3/2018/0008- proposed housing at 30 Peel Park Avenue, Clitheroe- flood risk and drainage.

APPLICATION CONSULTATION RESPONSE

Application Number:	3/2018/0008
Location:	30 Peel Park Avenue, Clitheroe
Proposal:	Demolition of existing dwelling and erection of 34 bungalows for the over 55s with associated access, parking, landscaping and open space.

Flood 1:- 30 year

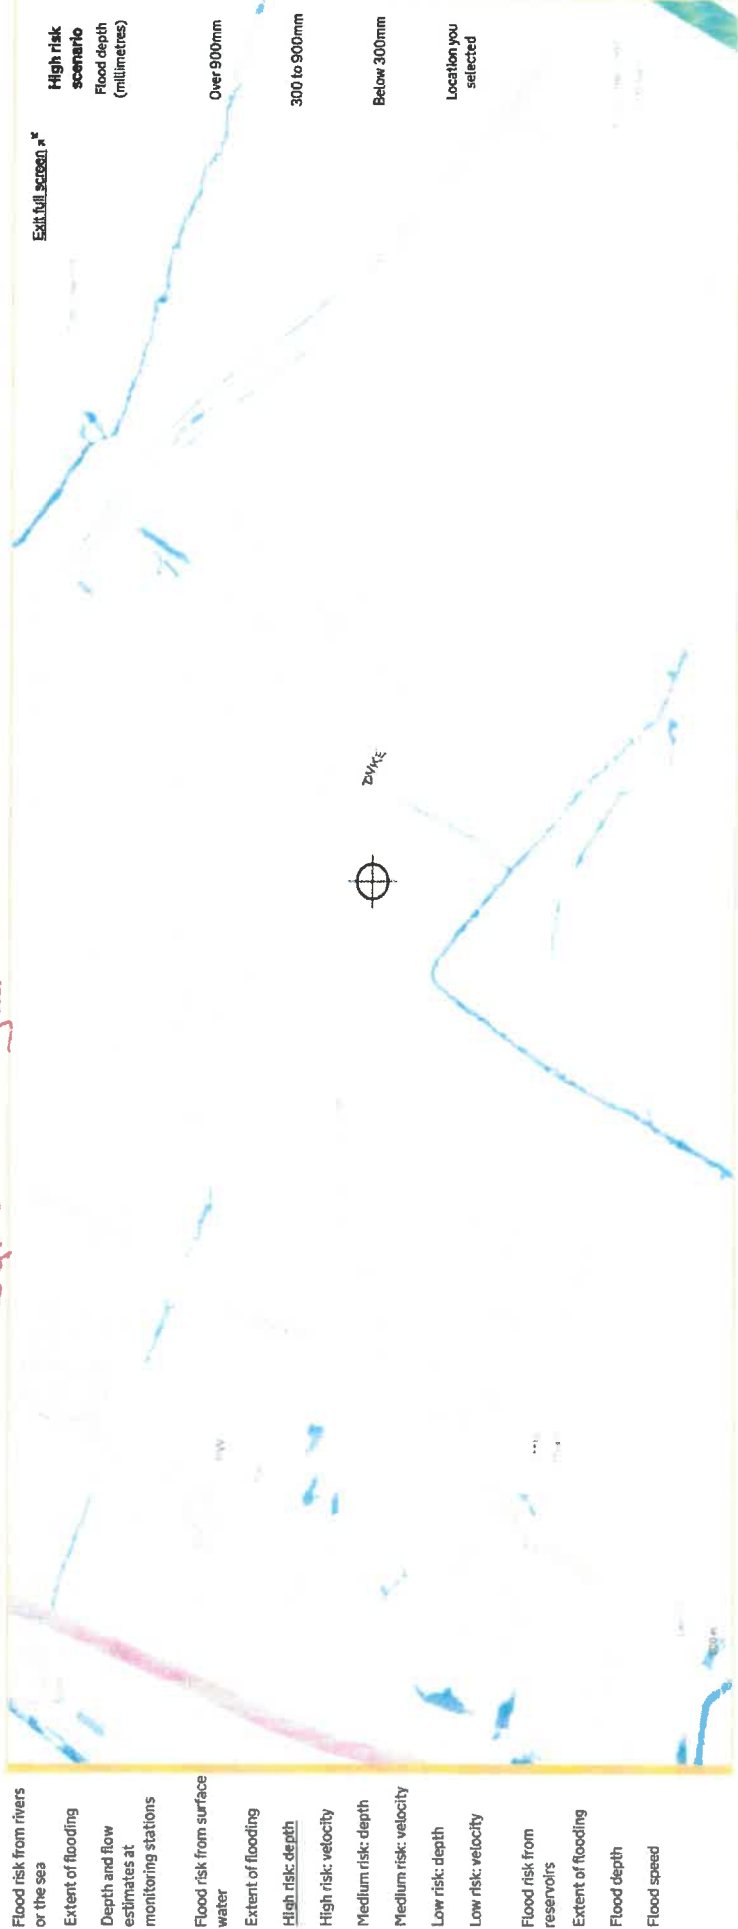
- a) Adequately assess the risk of surface water flooding to the site; specifically in regards to the surface water flood risk along the eastern and western boundaries of the site and the surface water flood risk around the proposed site access (including impacts on access/egress). The FRA also fails to provide sufficient details relating to mitigation measures that may be required in order to manage the risk of surface water flooding post development.

We provided Jflow/LIDAR mapping with our FRA on pages 12, 13, 14 of 171207attach2-A4 attachment and whilst this has limitations as per DEFRA guidance it does give a general assessment. For the avoidance of doubt we attach the same mapping at A3 size. A site walkover showed:-

3. The proposed site access shows no Jflow surface water risk at 1 in 30 year and as Jflow mapping does not accurately take account of existing drainage, the 1 in 100 year and 1 in 1000 year maps merely show that the roadway will shallow flood in severe storms. Please note that Peel Park Avenue slopes westwards at 1 in 20 average and even intense storms will not give much flow depth in the road gutters.
